**Consultation Response from KC,  
Highways Development Management**

**2023/93097 Land adjacent to, 196 Wakefield Road, Earlsheaton, Dewsbury, WF12 8AH**

**Erection of 5 dwellings (class C3) and ancillary office accommodation, formation of associated access, car parking and landscaping**

**Date Responded: 11-12-2023.**

Park View Road Elevation
Scale 1:100

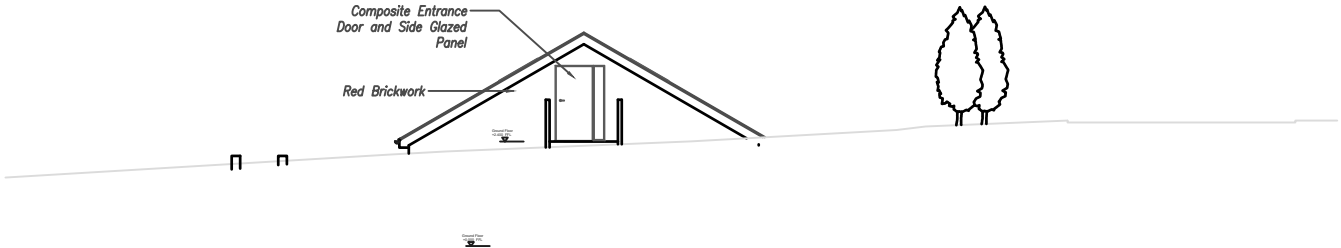
There are raised kerbs to the frontage of the proposed development to provide vehicle restraint at the top of the existing access. These kerbs will become redundant if the levels are raised to accommodate the proposed development.

Highways Development Management would ask that the condition requiring a 2.0m wide footway and retaining structures to the Park View frontage included within the 2018 and 2021 permissions is repeated for this application.

Notwithstanding the details shown on the approved plan, the development shall not commence until a scheme detailing the provision of a 2.0m wide footway, site access and associated works, including retaining structures, to the Park View frontage of the development site, construction specification, surfacing, drainage and kerbing and associated highway works has been submitted and approved in writing by the Local Planning Authority. The development shall not be brought into use until the approved scheme has been implemented and thereafter retained.
